Department of
Infrastructure, Planning and Natural Resources

Planning Assessment Report

Development Application DA 492-11-2003

The application seeks consent for the erection of a four (4) storey building with four (4) tourist units, ground floor retail space, parking, gymnasium and cinema.

Sun Study December 22 6:30pm

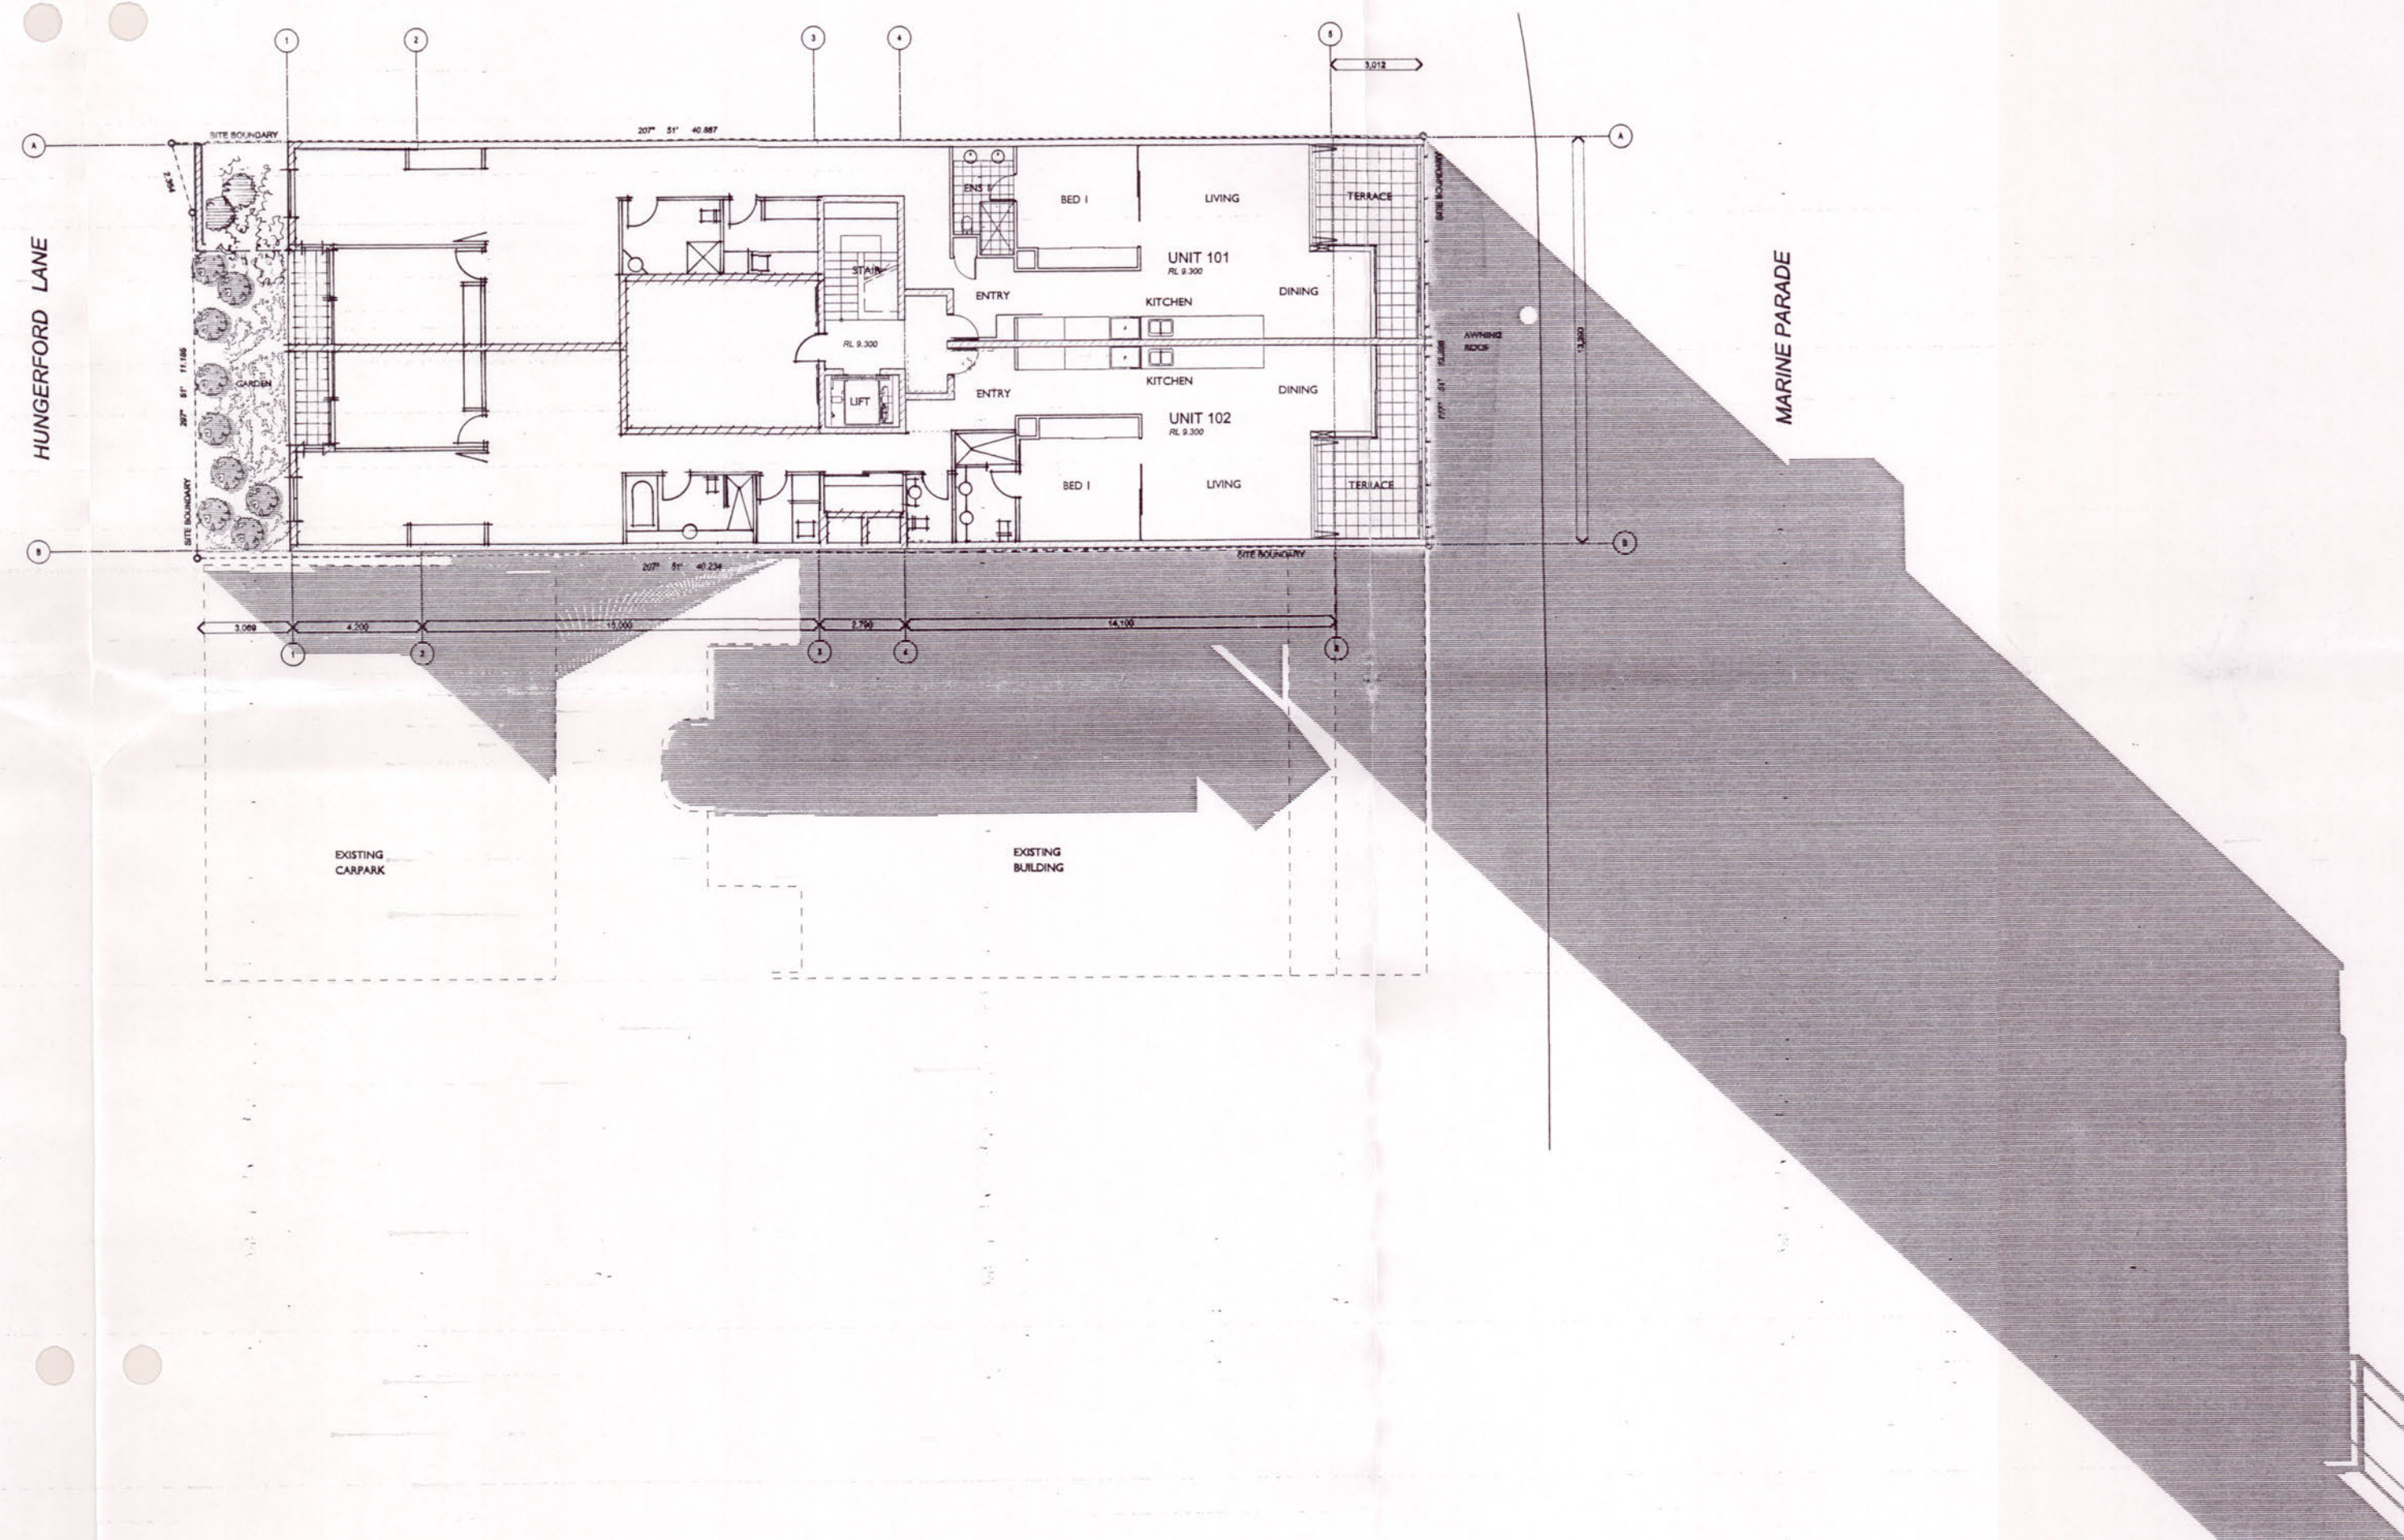
Issue: Clause 32B of the North Coast REP (NCREP) requires the consent authority

to refuse development applications which propose overshadowing of the foreshore at prescribed times of the day.

Consideration: Overshadowing of beaches is not permissible under SEPP71 and the NCREP. However, overshadowing during the summer months occurs on the foreshore park at 6:30pm on December 22. Overshadowing does not occur during winter months. The NRC is concerned that overshadowing will impact on ground cover and have an impact on dune stability. an objection under State Environmental Planning Policy No. 1 – Development Standards (SEPP 1) has been lodged by the applicant

Resolution: The overshadowing is considered minimal encroaching approximately 4m on an area with predominate tree cover adjacent to Marine Parade. Therefore it can be concluded that the overshadowing will not destabilise groundcover which is already shadowed by tree cover. This degree of overshadowing is considered acceptable with minimal environmental impact and impact on dune stability. The appropriate concurrences have been granted subject to conditions
